Marge Schmuckal - Re: Permit application for 122 Lynn Street

From: Marge Schmuckal
To: Scott Munson
Date: 7/23/2013 10:22 AM
Subject: Re: Permit application for 122 Lynn Street

>> I am in receipt of your permit application to add an 8' x 15' sun room

>> on the single family dwelling at 122 Lynn Street. I will need a more

Setbacks

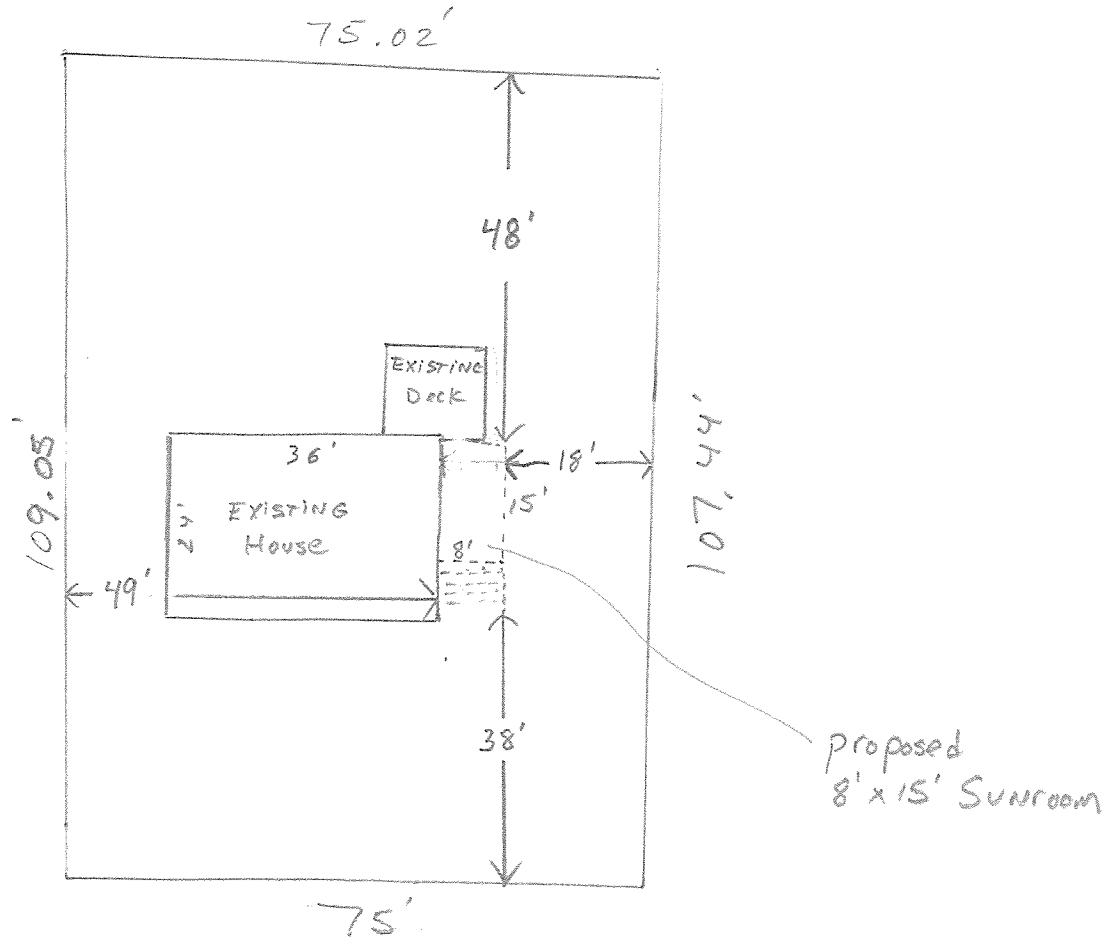
> So in essence there is 13' from the left side of the house to the
 > property line, then the house, then the new sun room (8' wide), then
 > an 18' setback to the right side property line. Is that correct?

>> accurate plot plan. The setbacks that you have given can not be

>> accurate. For side setbacks you have given $49' + 36'$ (house length) +

>> $8'$ (deck width) + $18'$ which adds up to $111'$. The lot is only $75'$ wide,

>> so these figures can not be correct. Please recheck your figures and

Yes, that better explains the situation. Thank you. I will sign off on the permit as meeting the zoning requirements.

> The 49' is from the left lot line over to the proposed sun room. So it
 > is 49' to the sun room, 8' wide sun room and then 18' to the right lot
 > line. $49' + 8' + 18' = 75'$

> It may look confusing on the plot plan but the 49' has an arrow from the
 > left lot line over to the right side of the house.
